SUBJECT: BRES2405-0069
BUILDING RESIDENTIAL

Here are the results of all Inspections located at **524 LONGLEAF DR:**

FOOTING PLAN	
FOOTING DETAILS	
524 LONGLEAF DRIVE—LILLINGTON, NC	Scale: NTS
Date: 9/9/2024	Revisions:
Donald D. Paschall, Jr., P.E. (PE License # 22543) 318 S. Spruce Street — PO Box 291 Proctorville, NC 28375 (910) 734-2005 donaldpaschall@gmail.com	
2 OF 2

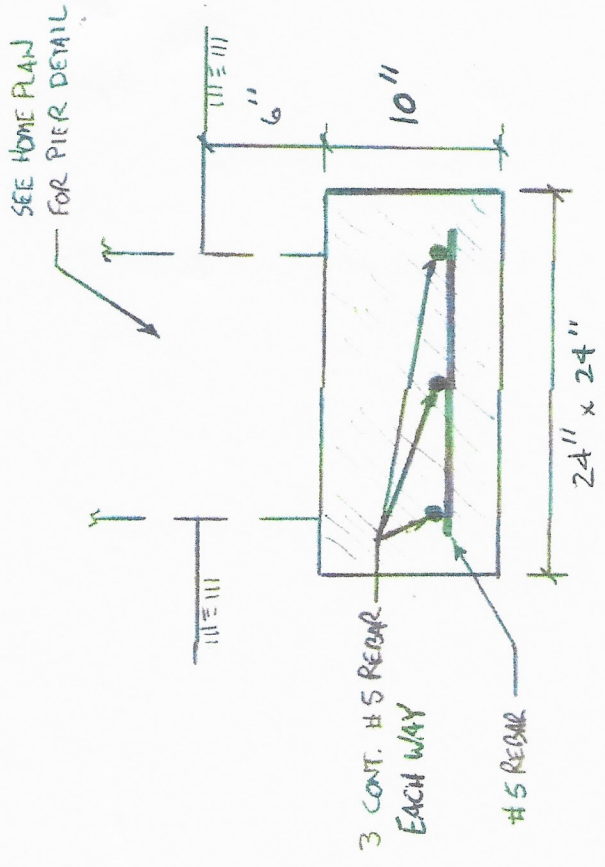
No plans in permit box
Need to clean loose dirt from bottom of footings
Need to mark depth of footings
Missing step downs in footings

Footing has water in them. Need to clean out and has crush and run in the footing. Need engineer letter
